Re: SP-16-00001

Thank you for the opportunity to comment on the short subdivision of approximately 81.14 acres into three 20 acre lots and one 21.14 acre lot, proposed by Ron and Deborah Mitchell. We have reviewed the application and Ecology asks that you consider these late comments.

SHORELANDS/ENVIRONMENTAL ASSISTANCE

**MITCHELL SHORT PLAT
PART OF SECTION 31, T. 20 N., R. 17 E., W.M.
KITITIAS COUNTY, WASHINGTON**

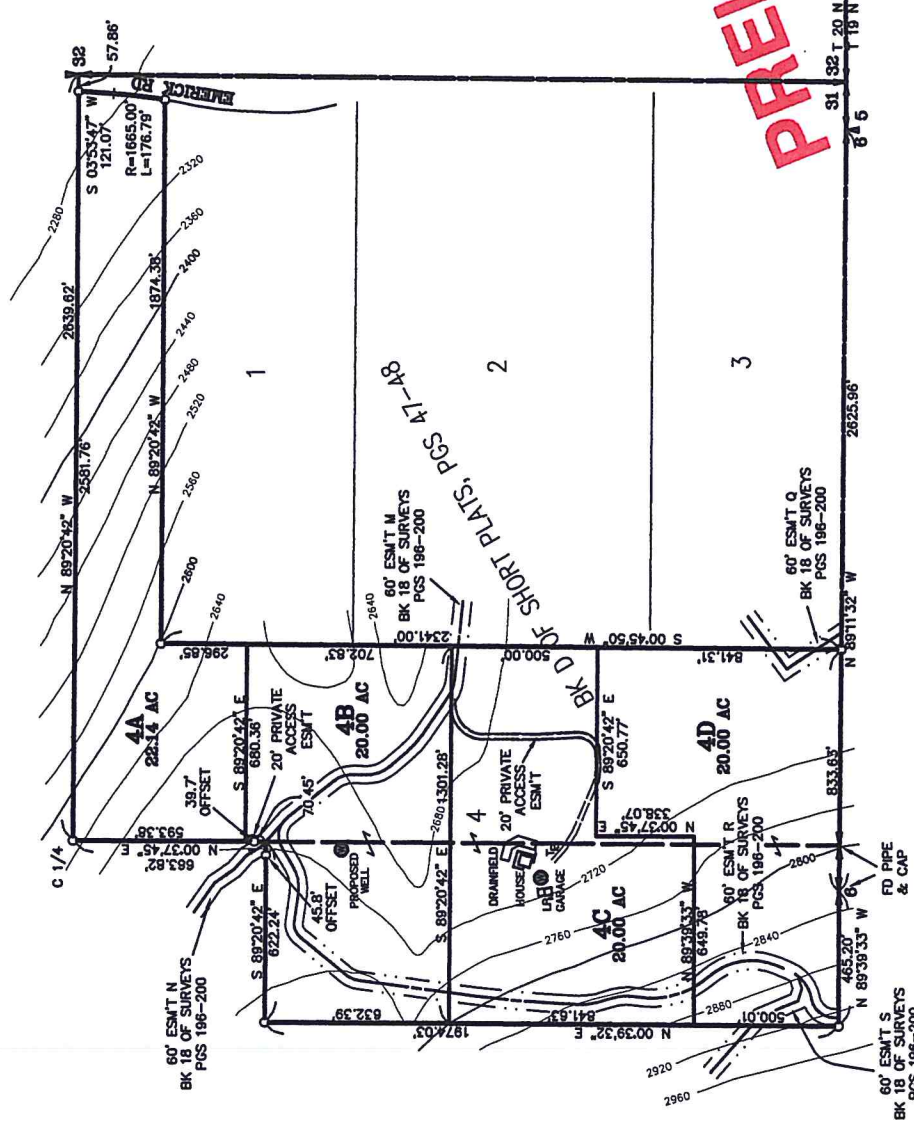
The result of our review is that there are likely to be wetland areas that are associated with the type 9 stream system that flows through the parcel, which is located primarily within proposed parcel 4B. The submitted critical areas checklist states that there are no wetlands on site. Was the site surveyed by a professional wetland scientist?

A close up clip from one of the photos submitted to Ecology via e-mail by a concerned neighbor is shown below. The location of the photo was purported to be in the vicinity of a proposed roadway and is possibly located within the drainage swale which is on site. The photo looks like it could be of a wetland area, given high water marks and wetland vegetation. Ecology has not been on site to verify soil conditions or the presence of this wetland in the corridor.

Ecology recommends that before any development (residences and other necessary infrastructure to support the residential development on site such as roads, utilities, septic, wells, etc.) occurs within these proposed parcels, that the development footprint and buffer areas are reviewed by a wetland professional to assure that wetlands are not directly or indirectly impacted. These proposed lots are of such large size that it should be easy for applicants to assure that construction clearing, wells, septic systems and roads are not placed within wetlands or within their required buffer areas.
